**From:** wilpshire parish council <wilpshireparishcouncil@gmail.com>  
**Sent:** 03 April 2026 14:38  
**To:** Planning; wilpshire parish council  
**Subject:** Comments on planning consultation: 3/2015/1002 Proposed extension of existing hardstanding within existing E/B2/B8 approved site. Including construction of 1.2m high stone retaining wall, weighbridge and associated cabin.

Wilpshire Parish Council would like to comment on application 3/2025/1002 Proposed extension of existing hardstanding within existing E/B2/B8 approved site. Including construction of 1.2m high stone retaining wall, weighbridge and associated cabin.

at Carr Hall Whalley Road Wilpshire as follows:

PROPOSED SITE PLAN 1:1000 @ A1

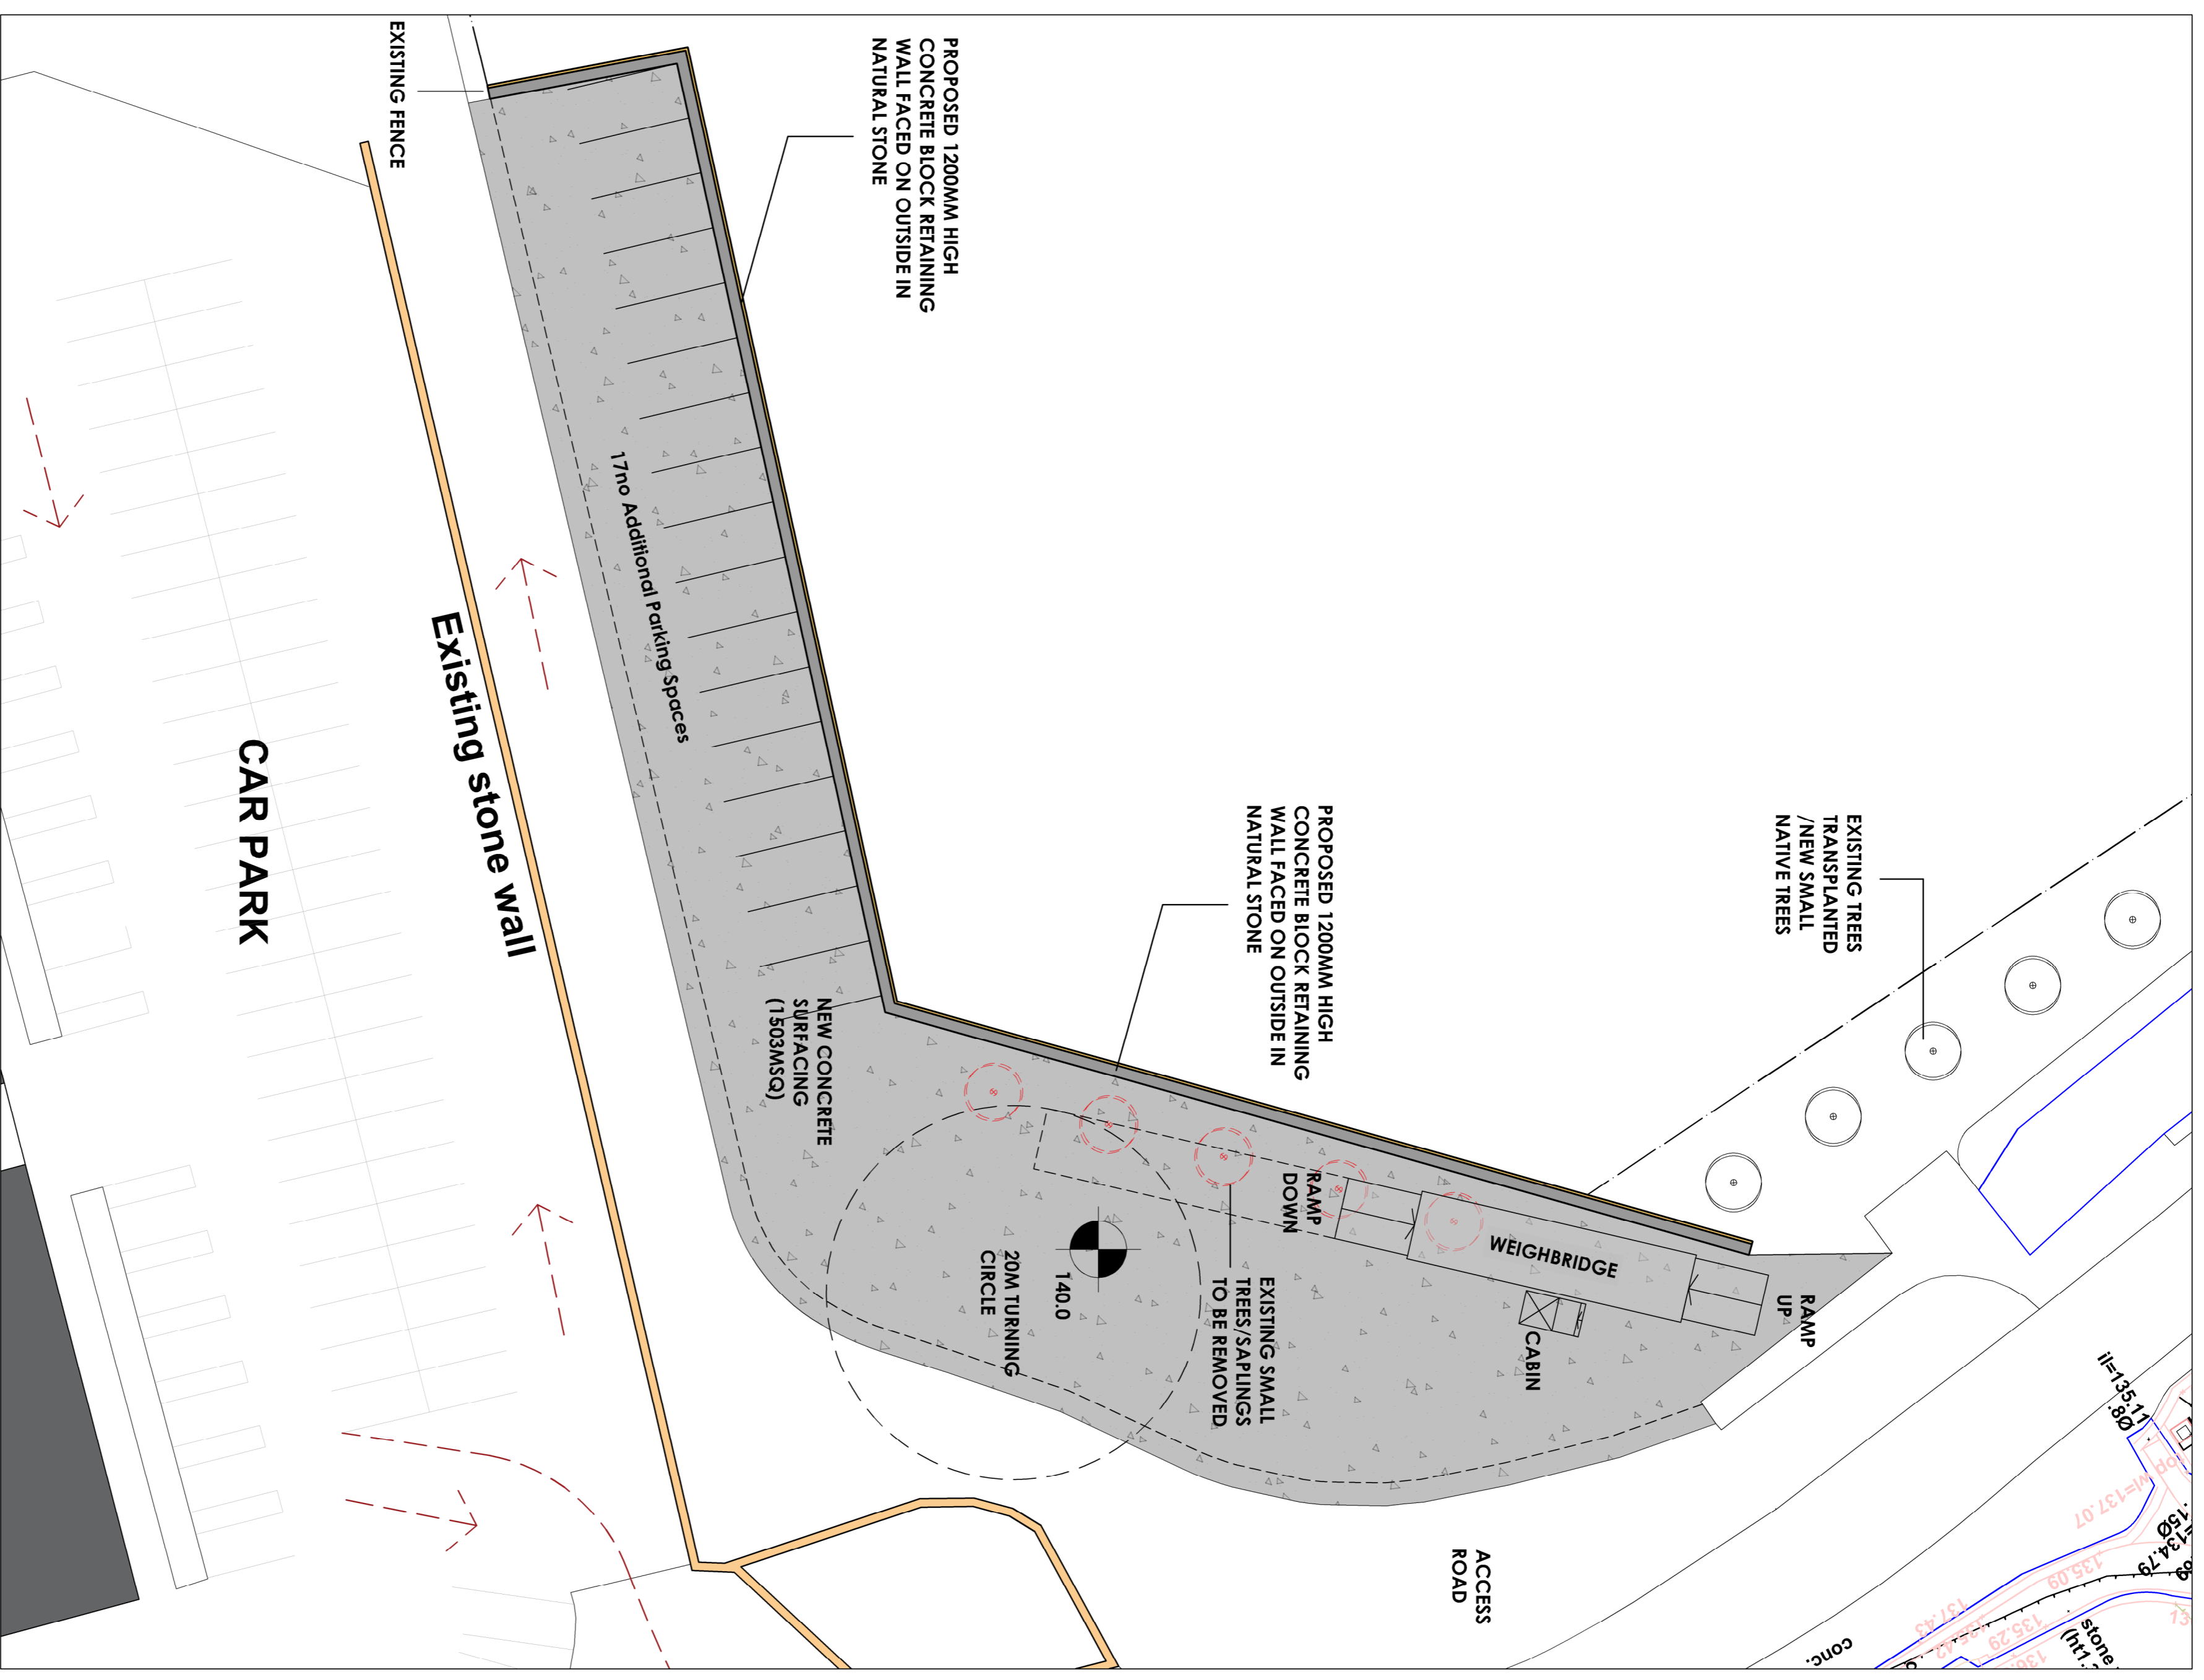
‘Wilpshire Parish Council objects to this application as the Council believes that the proposed parking along the spine road leading to Carr Hall is detrimental to the visual amenity of the Green Belt.

The Council further objects to the application as it believes that neighbouring properties will be subject to more noise and possible light pollution.

However, If the officer is minded to approve the application then Wilpshire Parish Council would ask that a condition is added to any approval to ensure that the pond on the spine road is protected as it is used by wildlife and amphibians have been seen in the pond by a Councillor.’
